From: Laura Gibbons [REDACTED]
Sent: 04 August 2020 16:46
To: Planning.Responses <Planning.Responses@arun.gov.uk>
Cc: Simon Davis <Simon.Davis@arun.gov.uk>
Subject: Y/59/20/DOC- Bonhams Field

Condition 12- surface water drainage design

CLIENT	Seaward Properties Limited				
PROJECT	Bonhams Field, Main Road, Yapton				
TITLE	Site Layout Proposed Drainage Plan				
DRAWN	M Pacifico		DATE	May 2019	
ENGINEER	S Magowan		CHECKED	SRM	
SCALE	1:500 @ A1 / :1000 @ A3				
			PROJECT NO.	23018	
			DWG No.	1210	REV. D

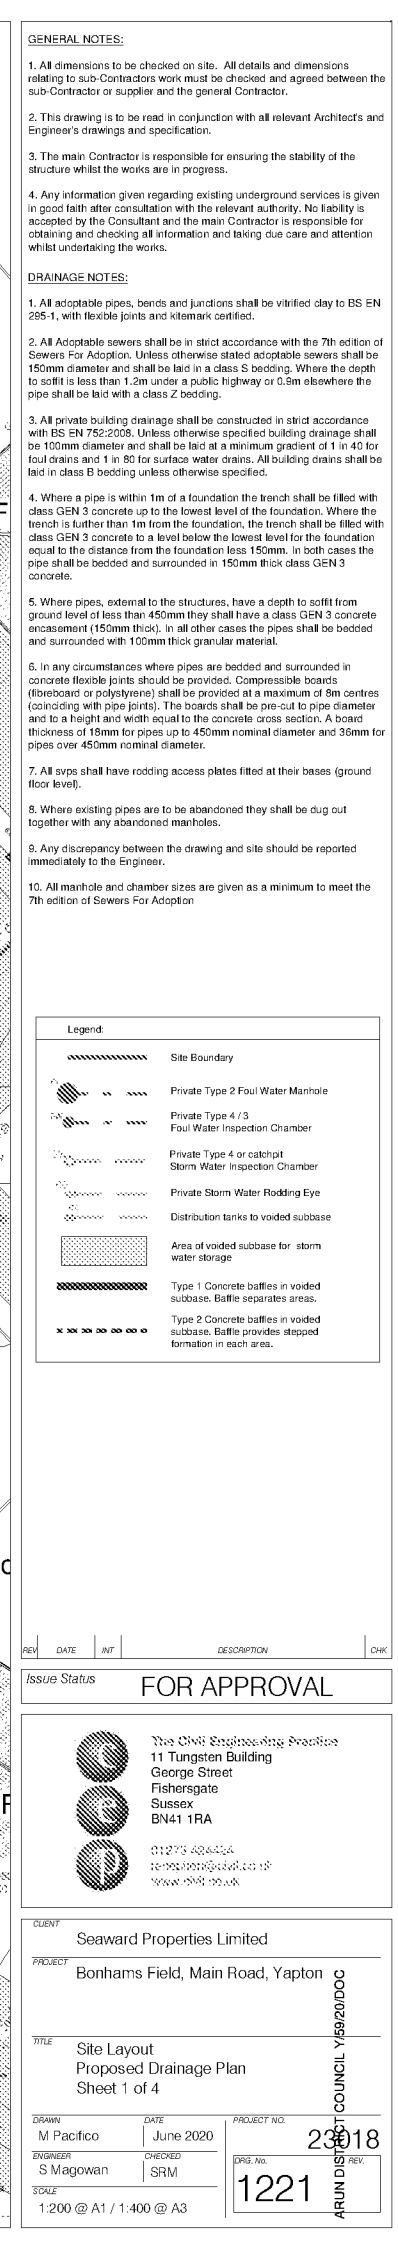
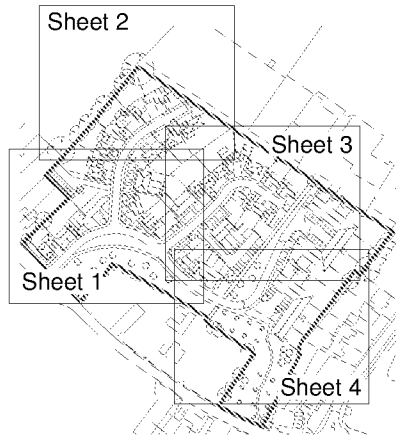
6. Once further site investigation is completed we will provide further comments. Based on a quick overview it is not evident whether the base of permeable paving is above peak groundwater levels, nor that all distribution tanks are at least a minimum of 5m from buildings.
